**KIRKLEES METROPOLITAN COUNCIL
INVESTMENT & REGENERATION SERVICE**

Reference No: 2018/62/90332/W

Site Address: Workshop, King Cliff Road, Birkby, Huddersfield, HD2 2RR

Description: Erection of extensions and alterations to workshop to form one dwelling (within a Conservation Area)

D	Amended elevation and dimensions	05.09.18	UH
C	Section added	01.08.18	UH
B	Proposal reduced in scale	13.06.18	UH
A	Updated site boundary	26.03.18	UH
REV	DESCRIPTION	DATE	DRAWN

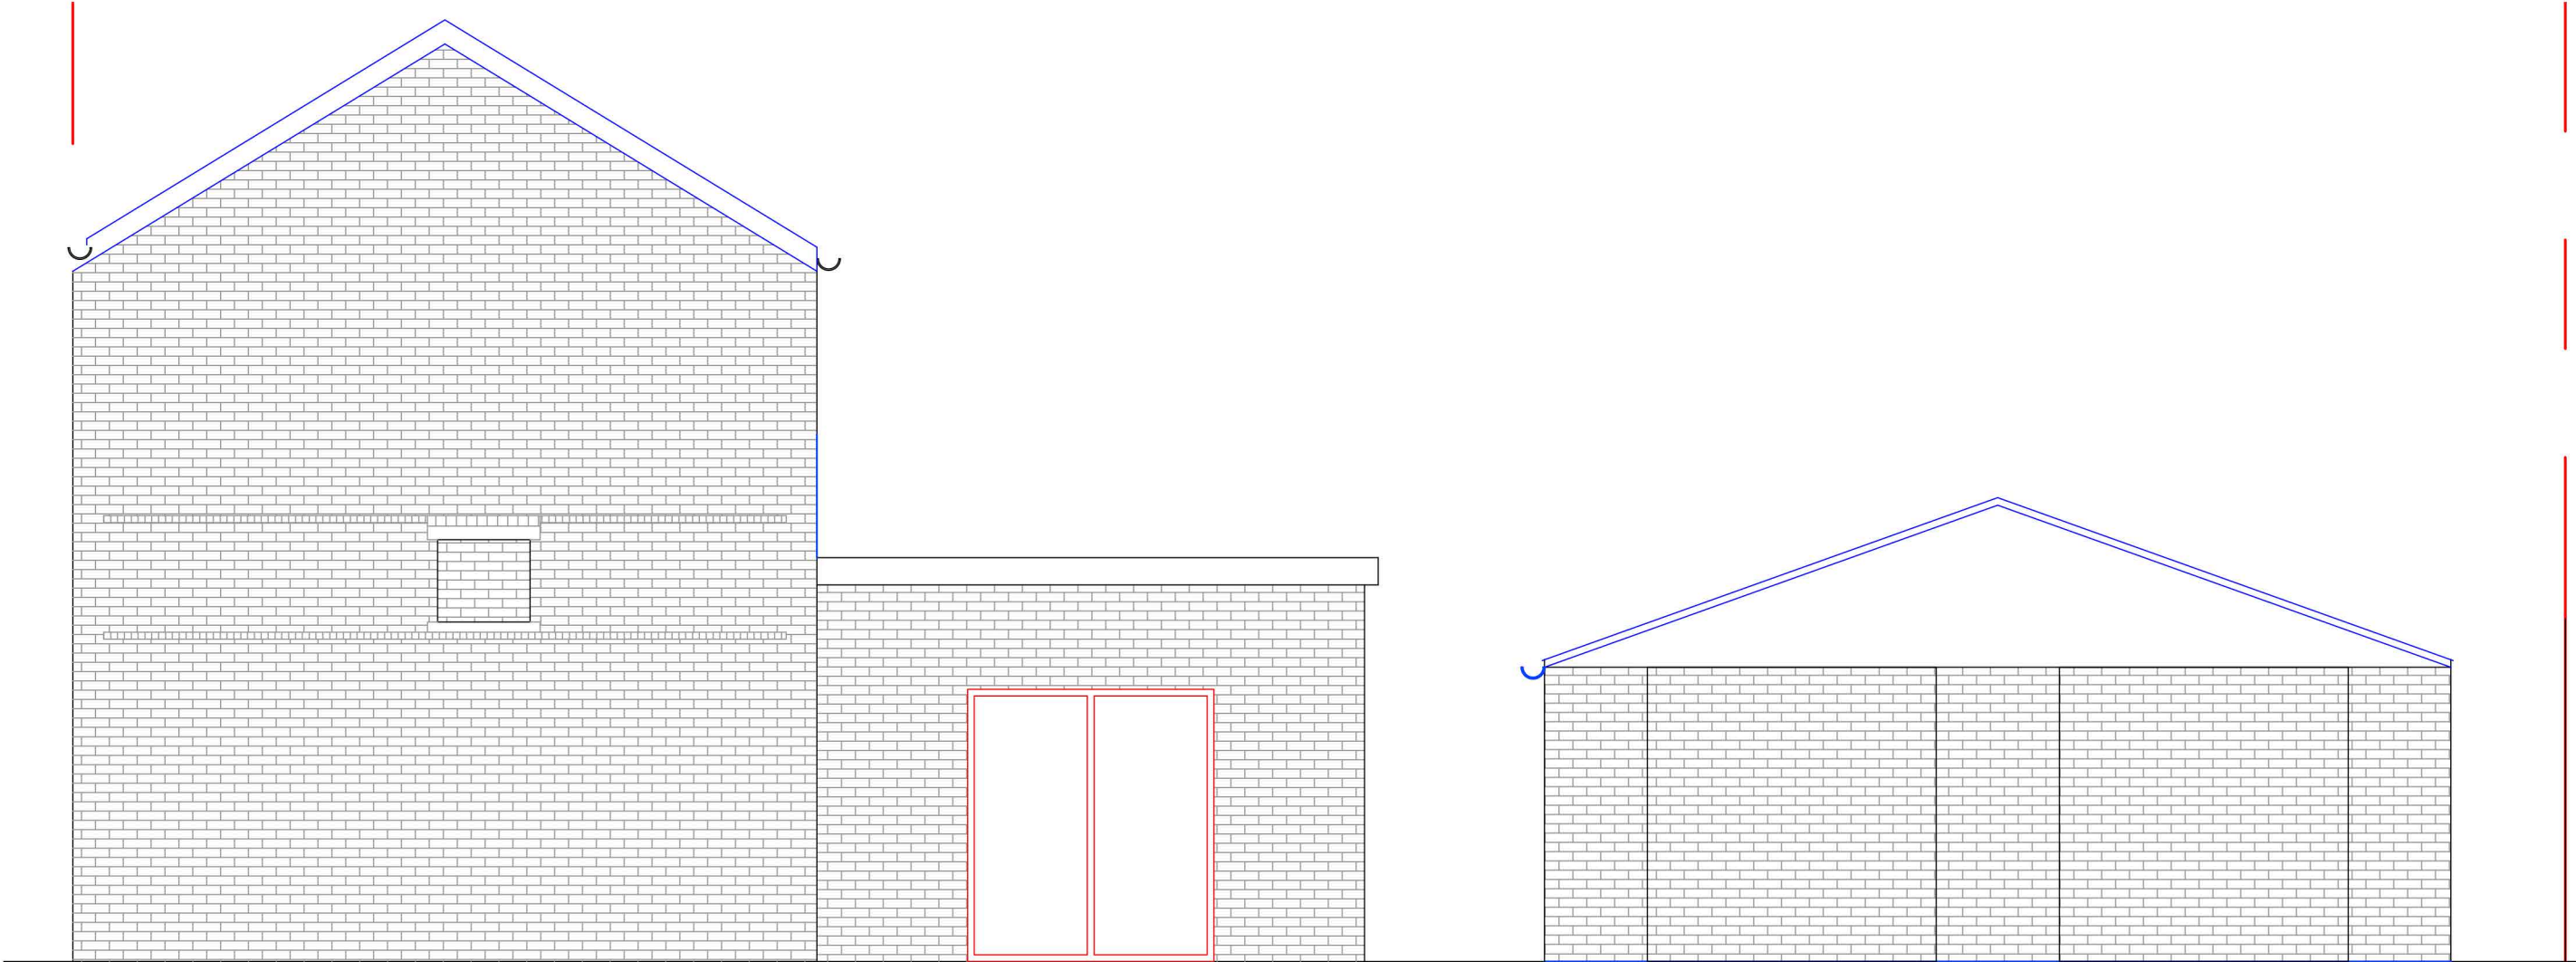
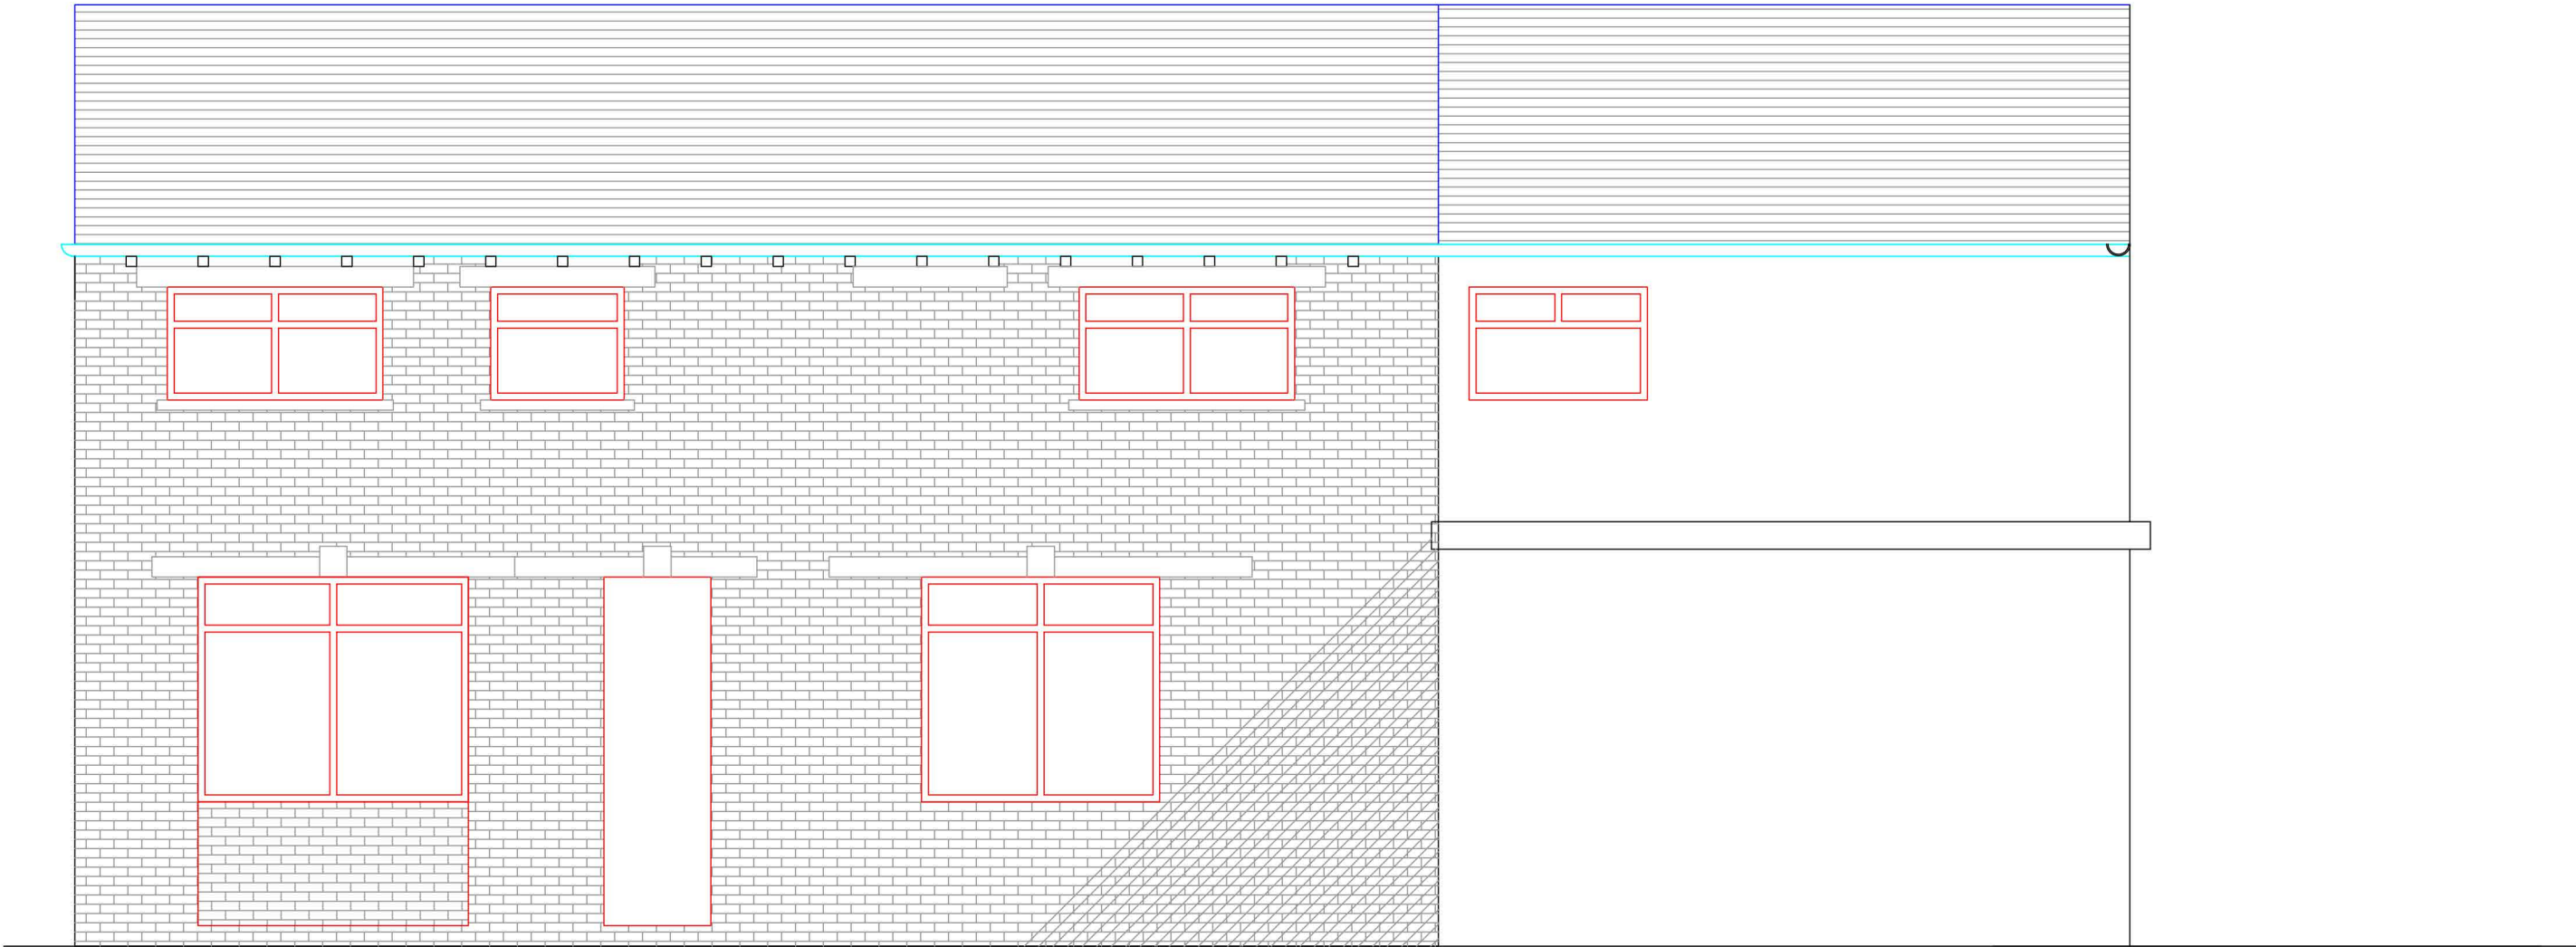
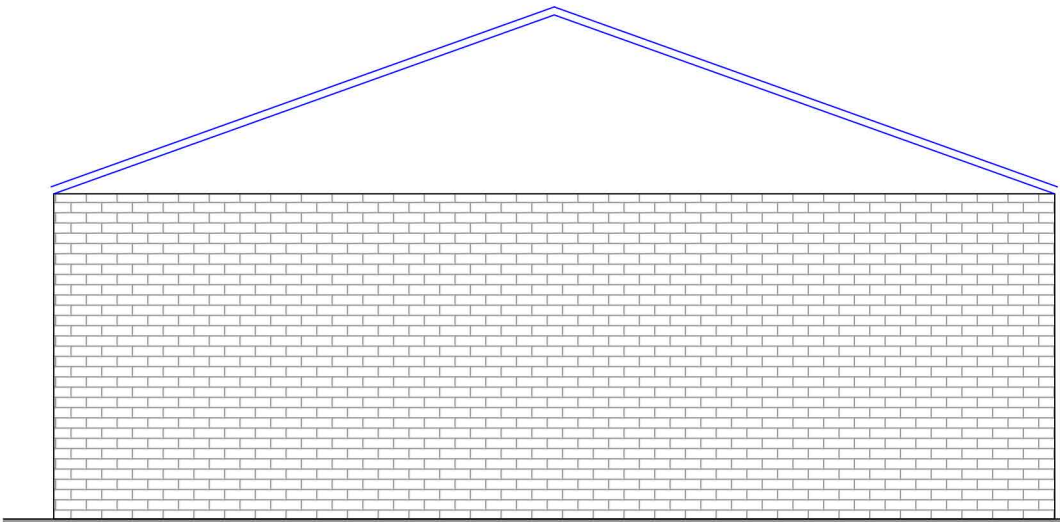
"The trees information provided shows that there will be no direct impact at the construction phase on the adjacent protected trees so I've no objections on those grounds. Although I do have concerns about shade issue with the windows located on the rear elevation. Given the size and proximity of the trees, these windows will have suffer shade issues, this will lead to future pressures to fell or excessively prune the protected trees. We really need to see these windows moved from the rear elevation to the sides so they are not dominated by trees conflicts".

Consequently, the proposals have been revised again to address overdevelopment issues. The revised scheme now omits the openings referred to above, by the Tree Officer and as such addresses the concerns in relation to shading.

Side Section

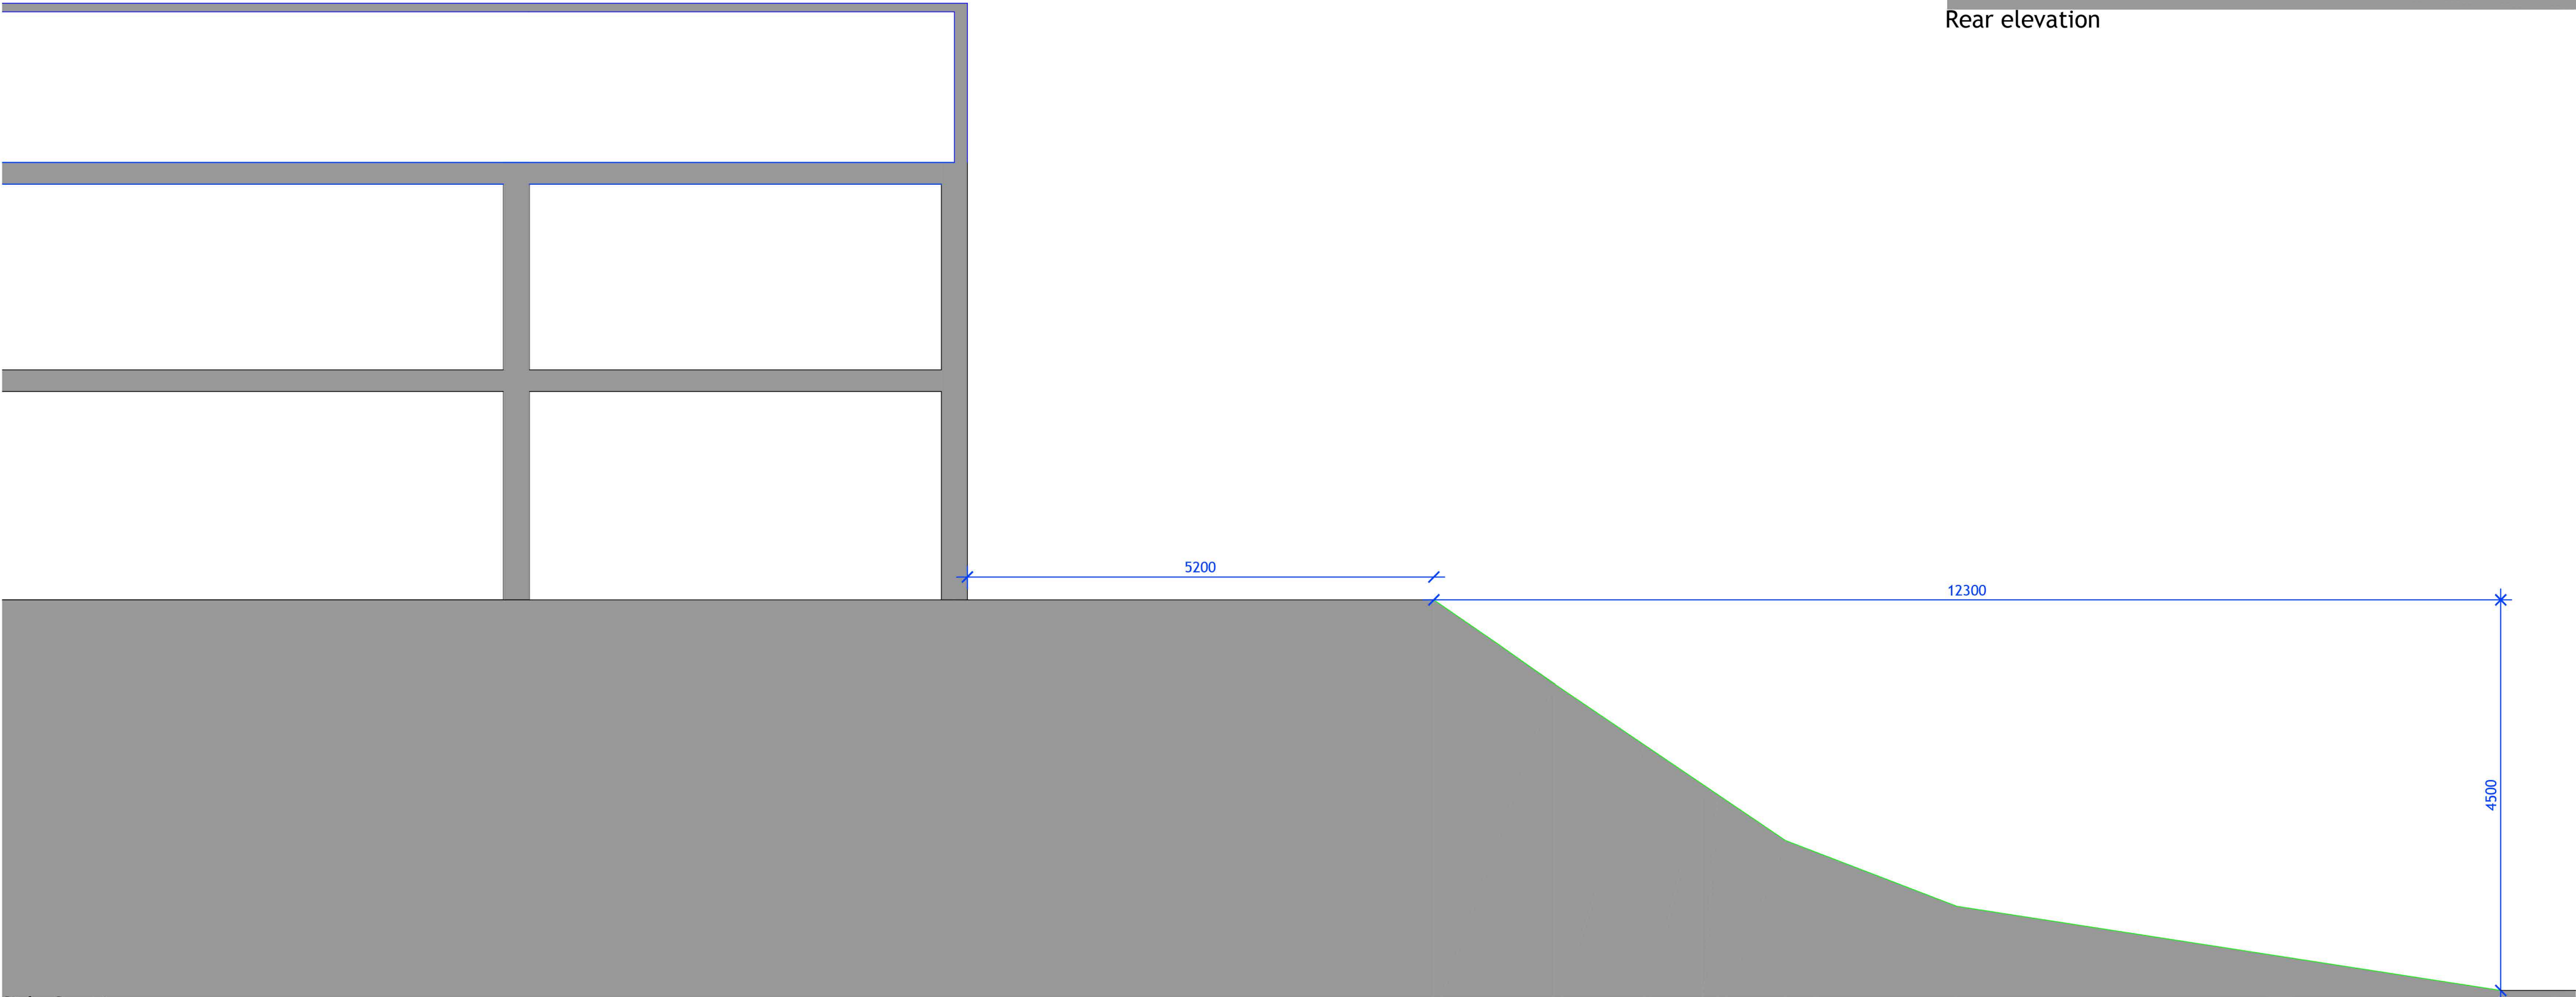
The proposals have been revised and a section showing the extent of the proposed development in relation to the adjacent land towards Jack Hill which carries a public highway been provided. On assessment of this information the Councils Structures team is satisfied that the proposed development is located sufficiently away from the existing highway to have any adverse impact on it, in accordance with paragraph no. 178 of the NPPF.
